# Immingham Green Energy Terminal

## 10.6 Proposed Change Application Report

May 2024

Document Reference: TR030008/EXAM/10.6

LEGEND

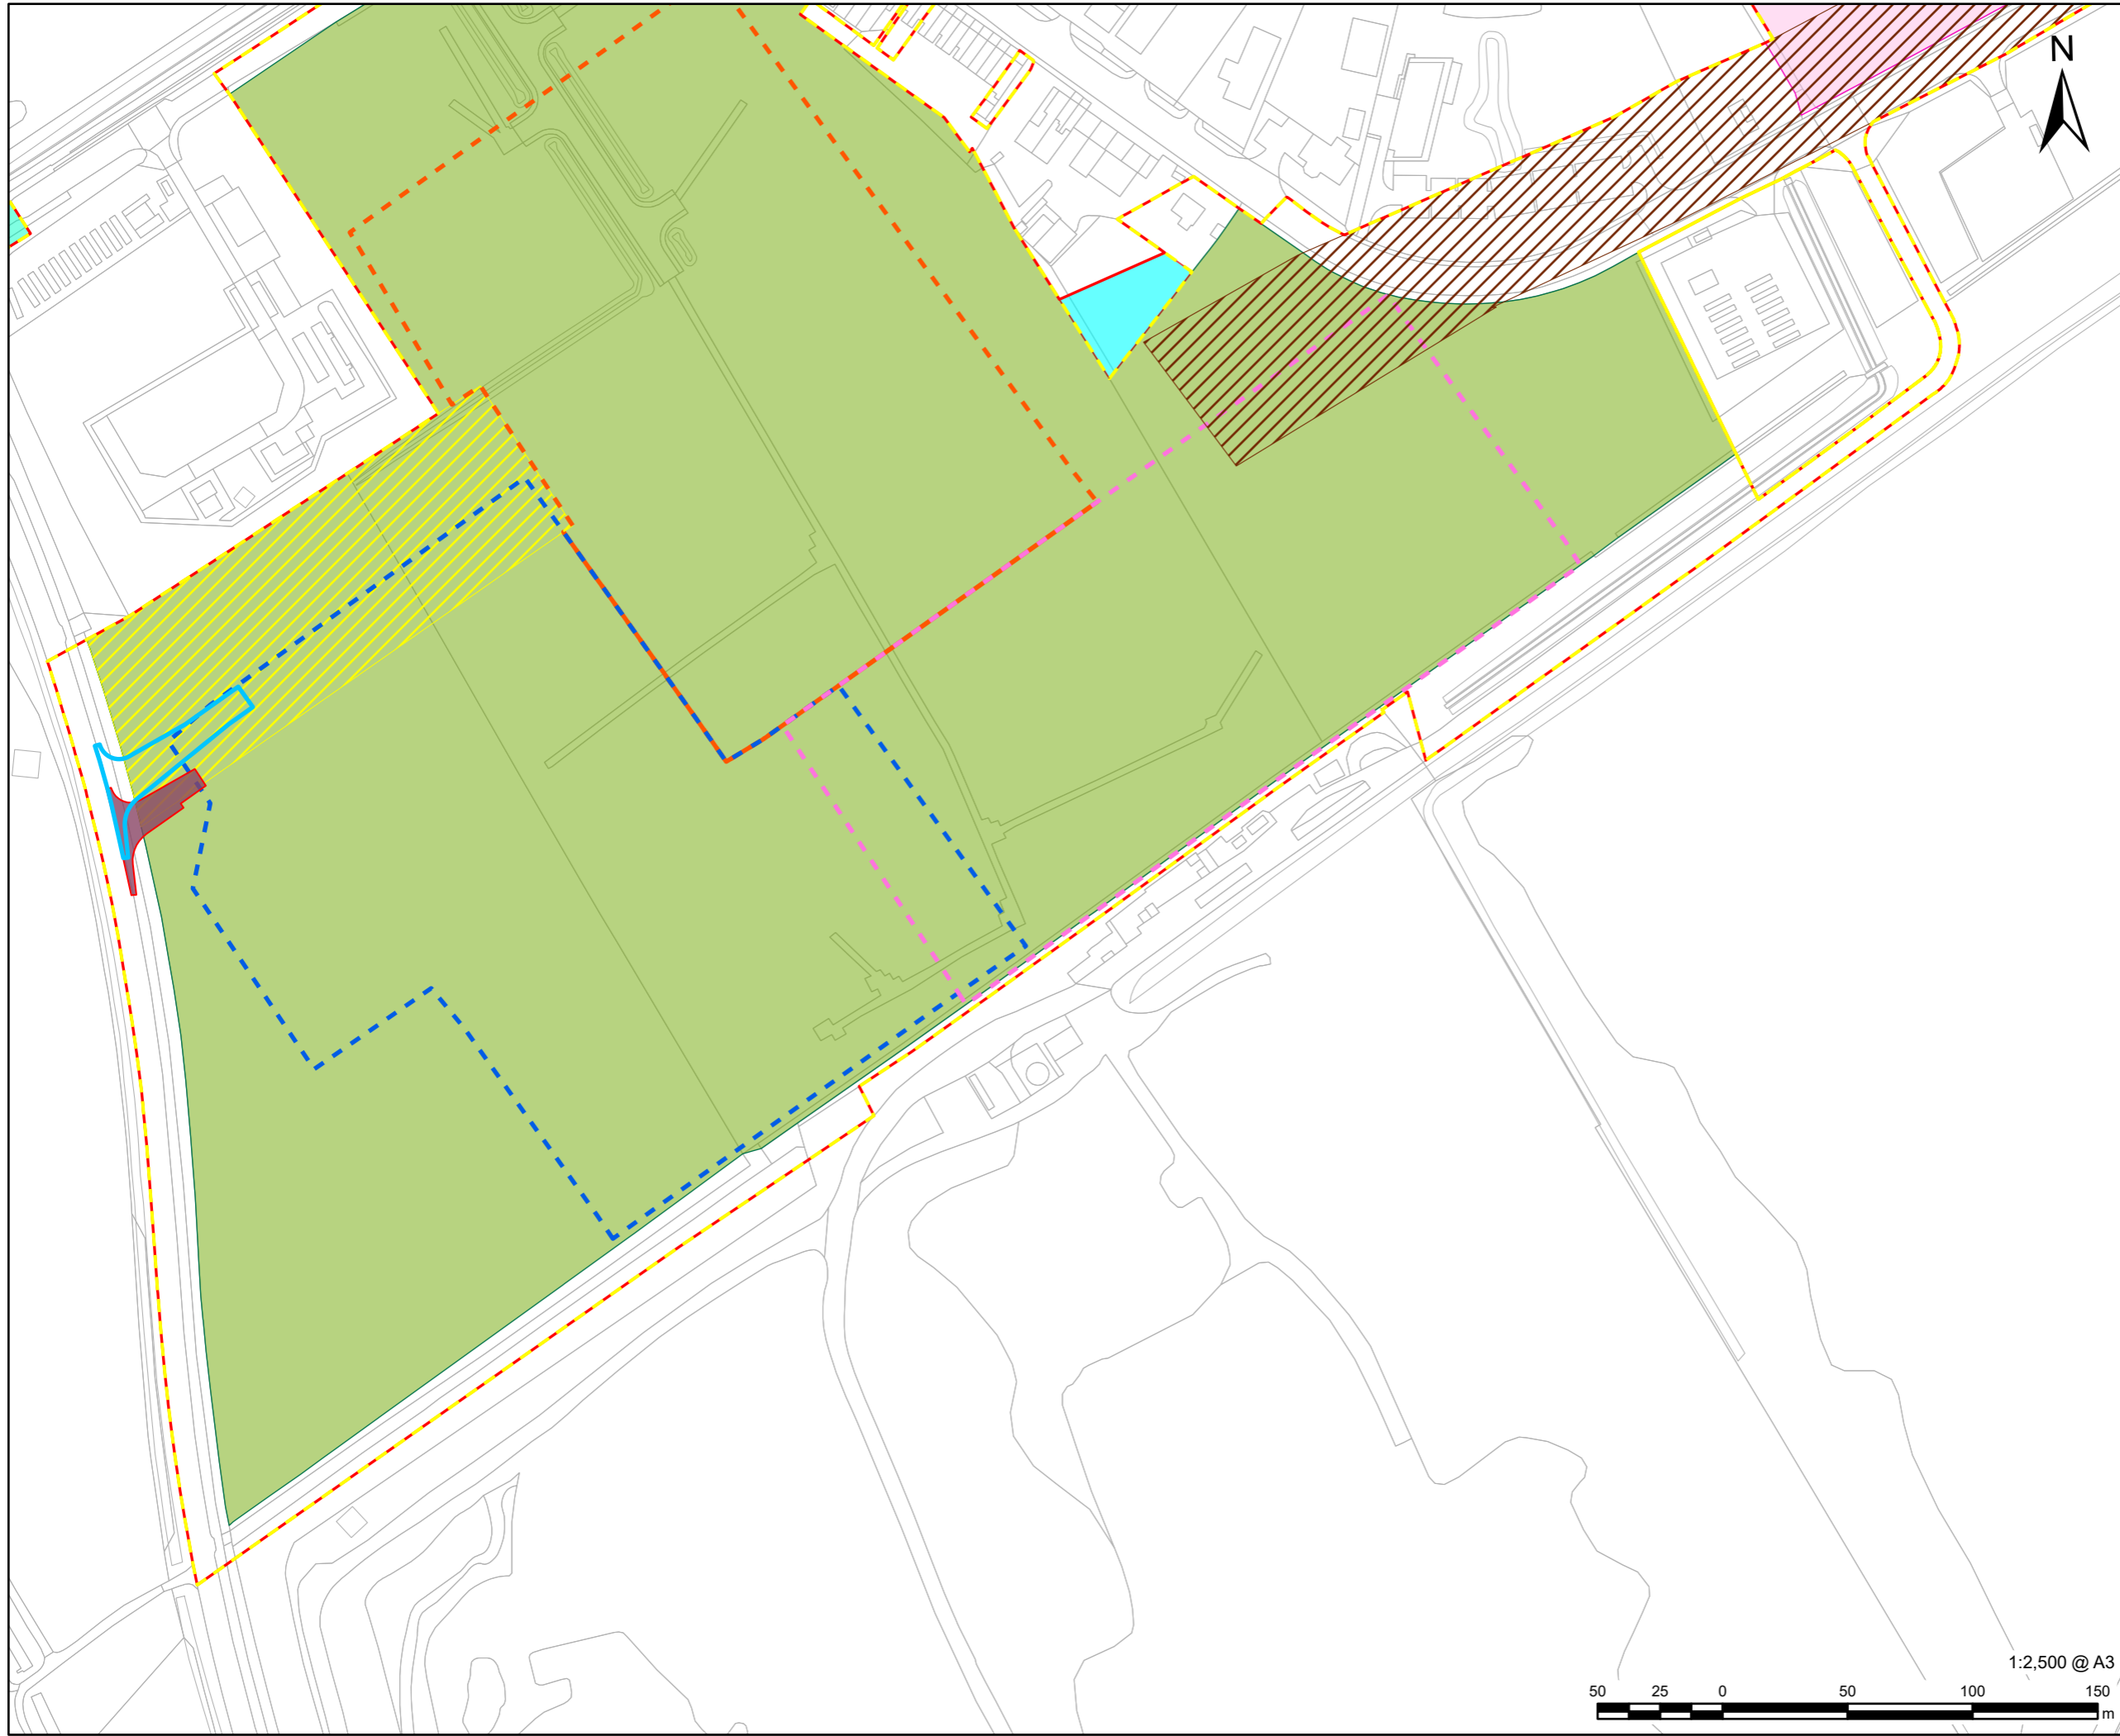
- 2.4.1 Proposed Change 3 comprises minor changes to the northern access from the A1173 to Work No. 7 (marked “AB” on the **Street Works and Accesses Plan [TR030008/APP/4.6(2)]** and referred to as “Access AB” below) and amendment of the Order Limits (red line boundary) at the eastern edge of Work No. 7 to include additional land for temporary construction purposes.

- 2.4.3 Proposed Change 3 requires the extension of the Order Limits to include a small area of additional land to the east of Work No. 7. The inclusion of this land is for the purposes of construction, and therefore powers of temporary possession are sought in respect of this land, rather than powers of compulsory acquisition. As a result, the CA Regulations are not triggered by this Proposed Change 3 (further detail on this set out in **Section 7** of this Report).. Proposed Change 3 does not require an amendment to the **Outline Construction Environmental Management Plan [TR030008/APP/6.5(3)]**.

- 2.4.4 Proposed Change 3 also includes minor changes to Access AB. As a result of the slight shift of the likely layout of the hydrogen production facility, Access AB needs to be adjusted by approximately 10–15 metres to the north-west.

- 2.5.2 The visual addition of the walkways in the **Works Plans [TR030008/APP/4.2(3)]** is shown indicatively in **Figure 5** below and on **Sheet 1 of 2** in **Appendix 4**.
